Application for removal or variation of a condition following grant of
planning permission. Town and Country Planning Act 1990.
Planning (Listed Buildings and Conservation Areas) Act 1990

Title:	Mr	First Name:	Paul	Surname:	Dunne
Company name:					
Street address:	Granham House Barn, Hothersall Lane				
	Telephone number:				
	Mobile number:				
Town/City:	RIBCHESTER				Fax number:
Country:					Email address:
Postcode:	PR3 2XB				
Are you an agent acting on behalf of the applicant?					
<input checked="" type="radio"/> Yes <input type="radio"/> No

SK suggested to submit a variation of condition application including new revised elevations (elevations included as part of application - drg.no.14.13 PL02 Rev. B)

The development hereby permitted shall be carried out in complete with the proposals as detailed on the submitted drawing, namely:
14.13 PL02 Rev.B

drg.no. 14.13 / PL02 rev. B

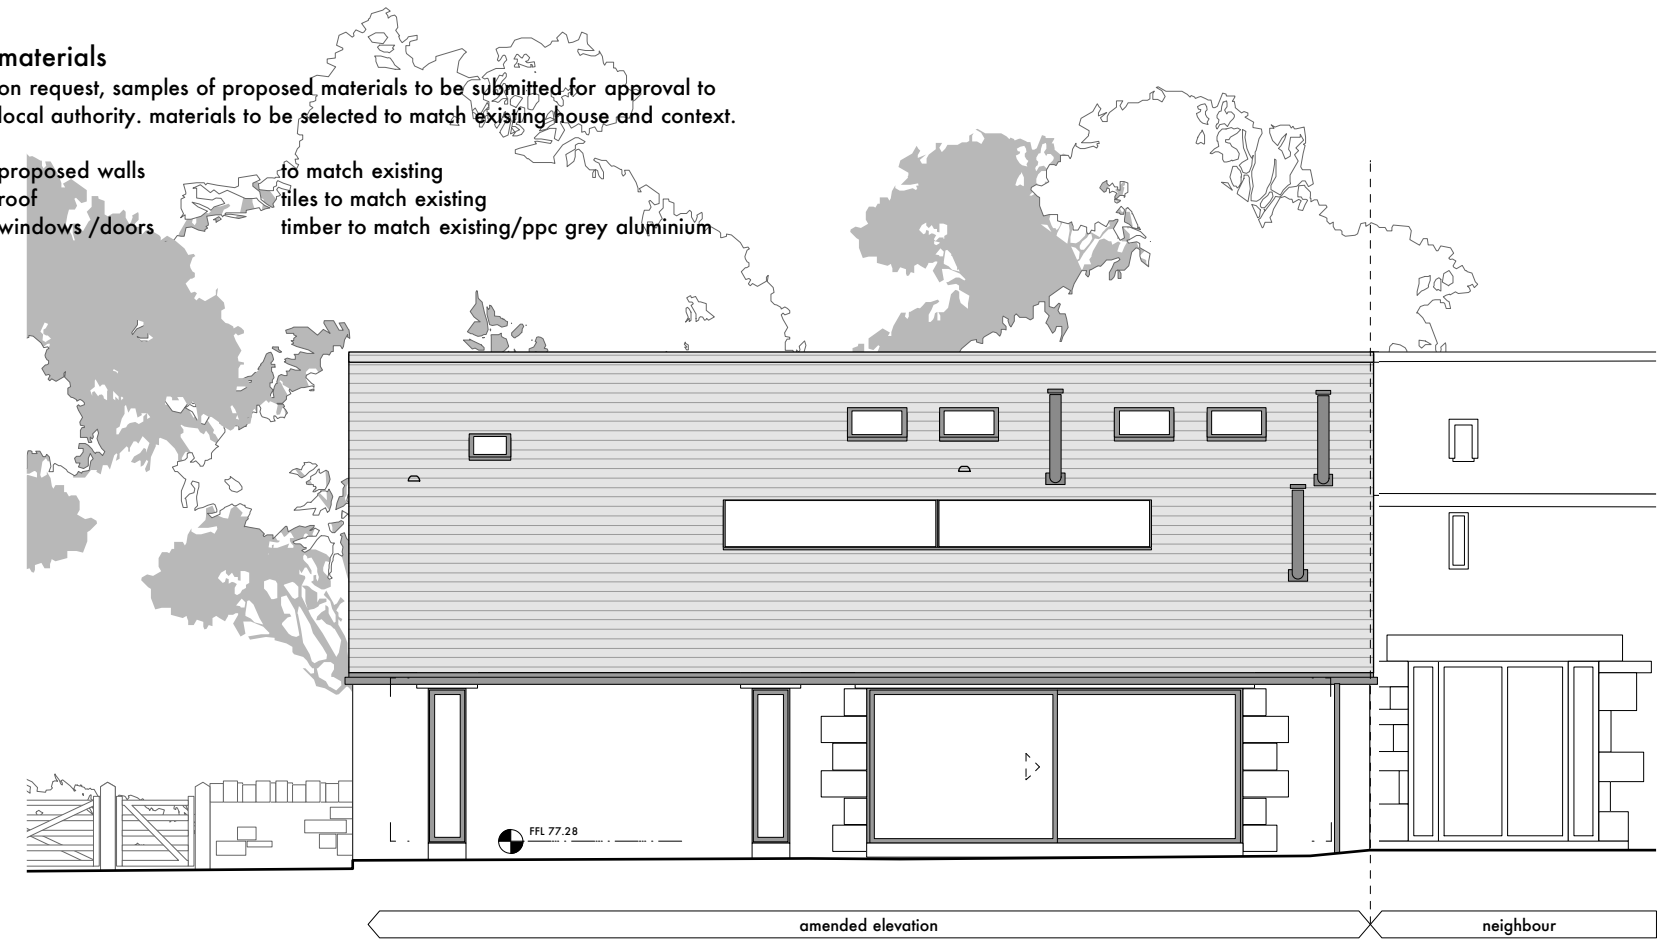
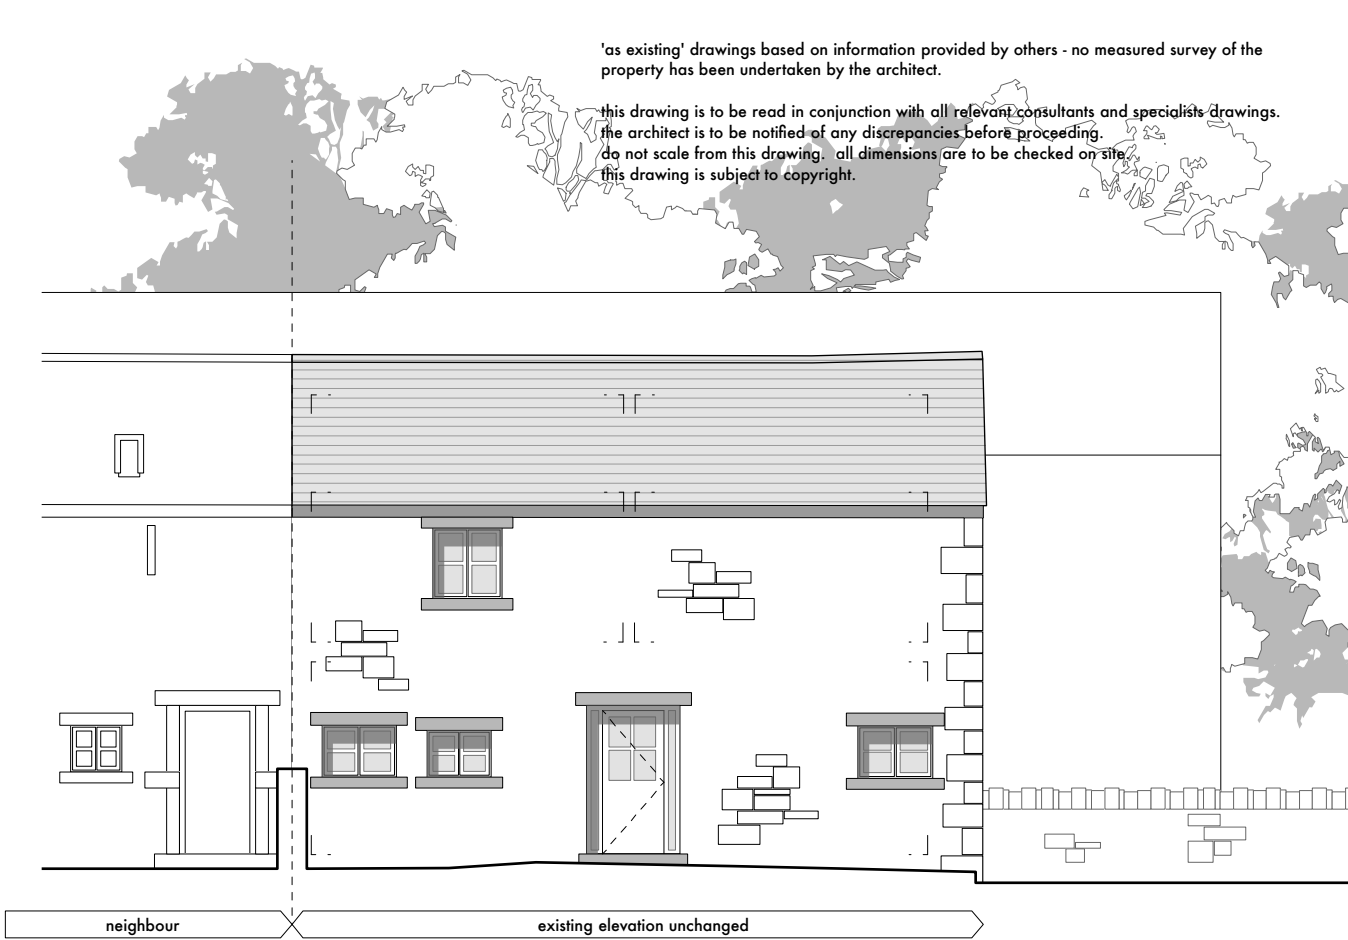
SK explained that the extent of deviations from the approved elevations are to such a degree that a revised application would be required as the matters could not be incorporated as part of the current application.

variation to condition 3 to allow for the development to be carried out with the current amendments to the windows and rooflights after structural implications occurred and pragmatic detailing was required as work began to progress on site
